Comments for Planning Application 24/00083/VARN

Application Number: 24/00083/VARN

Address: Stockbridge House High Street Stockbridge Hampshire SO20 6EX

Proposal: Variation of condition 02 (approved plans) of 21/01171/FULLN (Erection of three tourist accommodation units) to alter the provision of windows, install decking platforms, and changes to internal configuration

North West Elevation

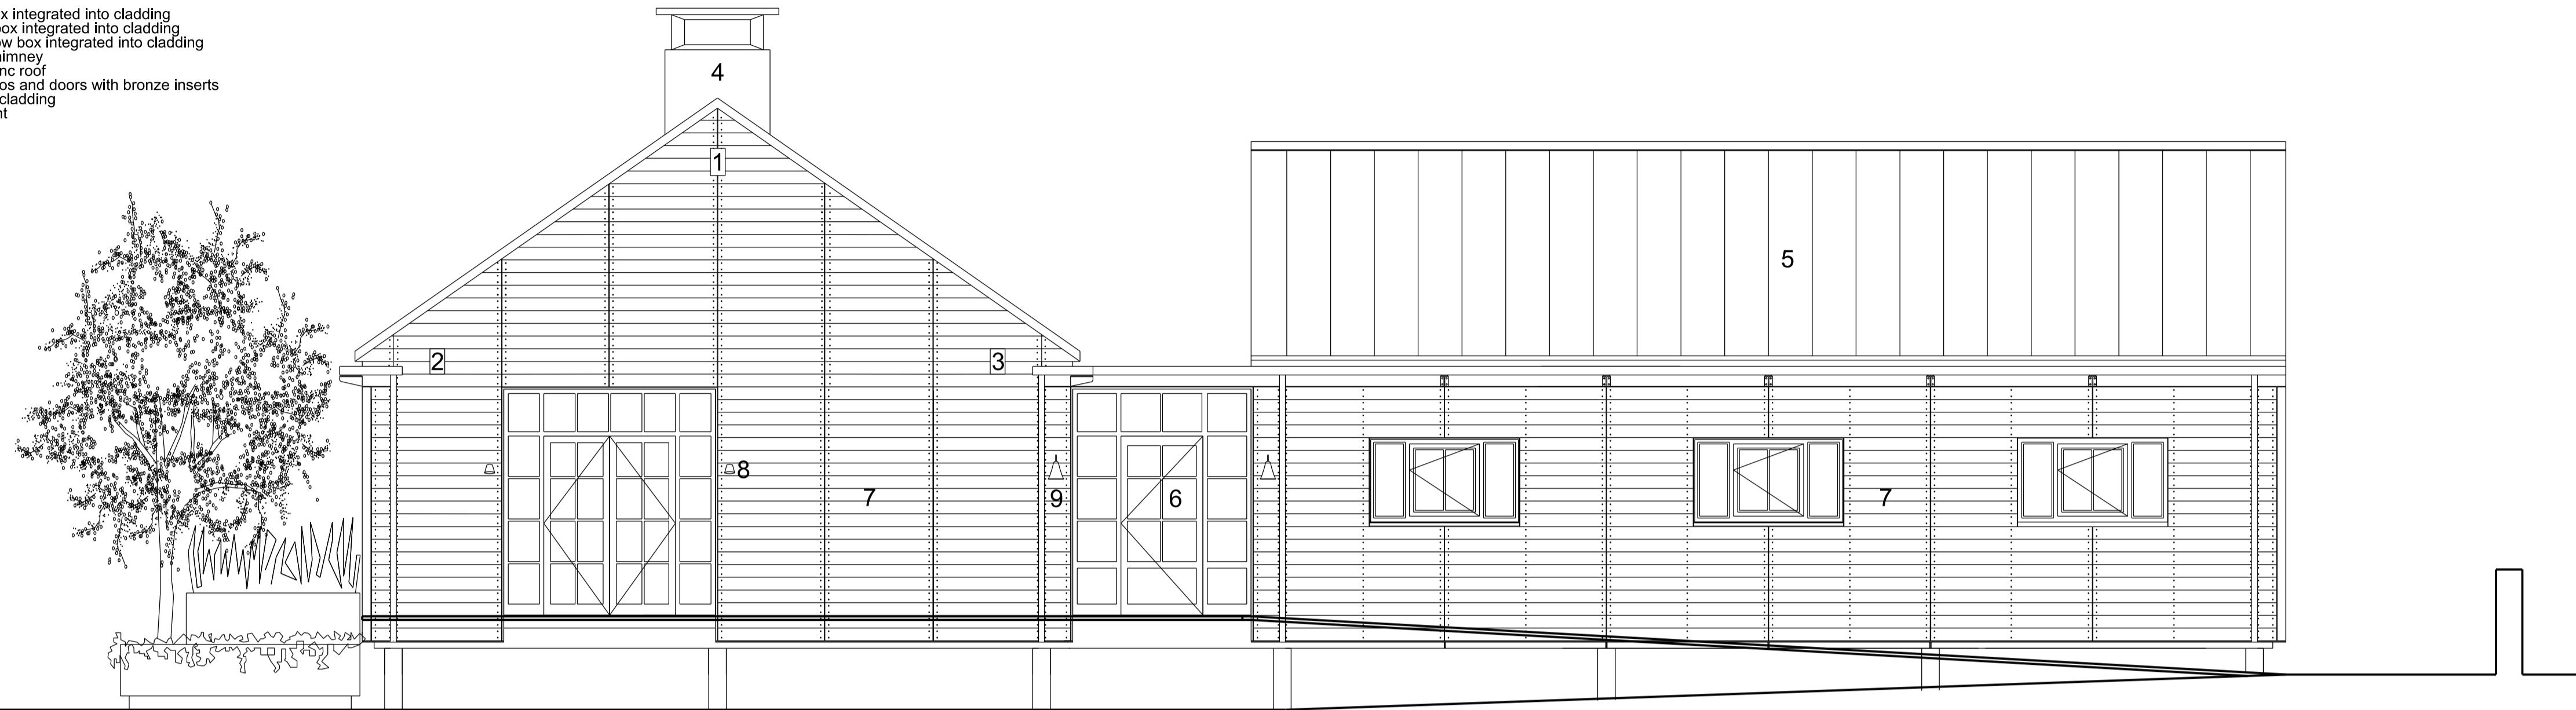
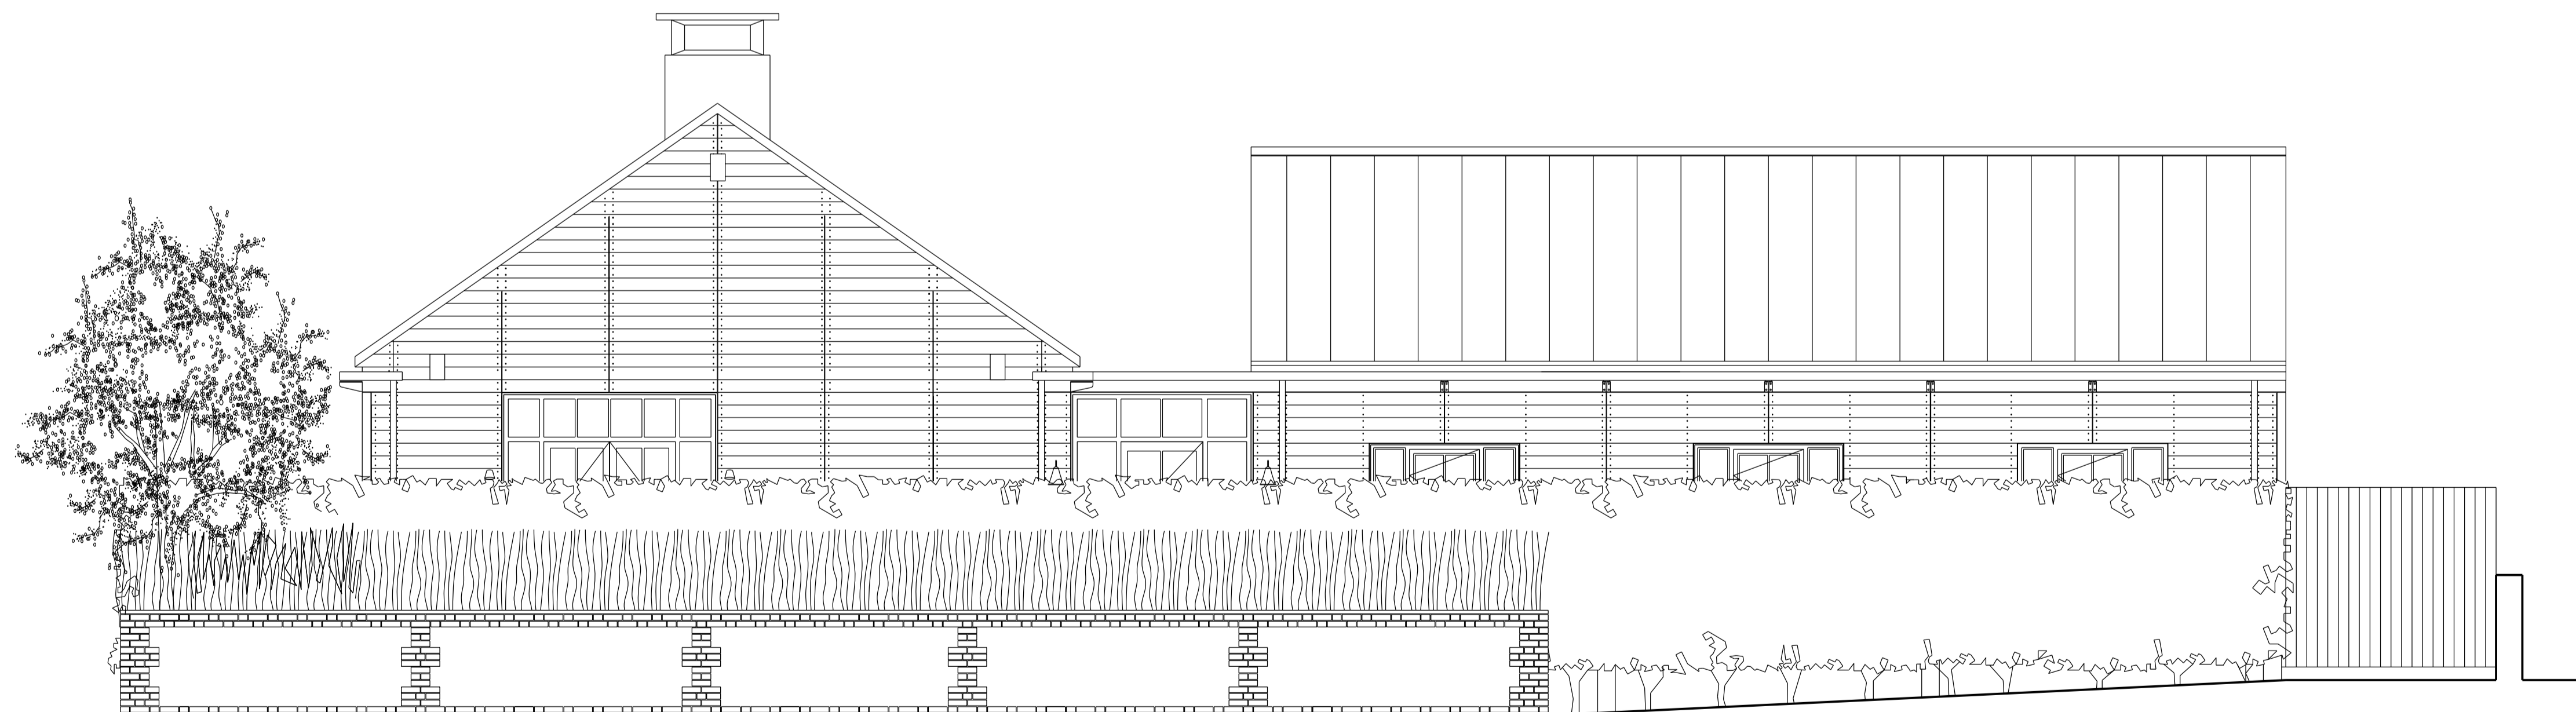
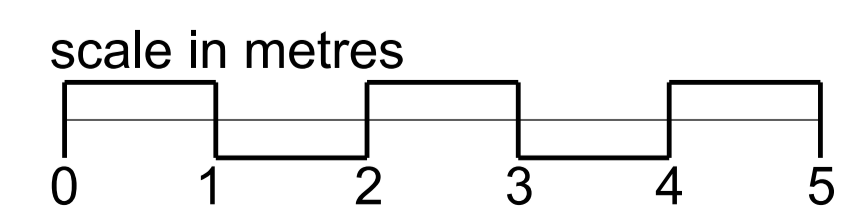
Also I object to the further proposals esp the proposed decking area and new French doors on the northwest side of the building which will have an impact on both privacy (overlooking) and potential noise to the back gardens of us and our neighbours Homeleigh and Tilers Cottage .
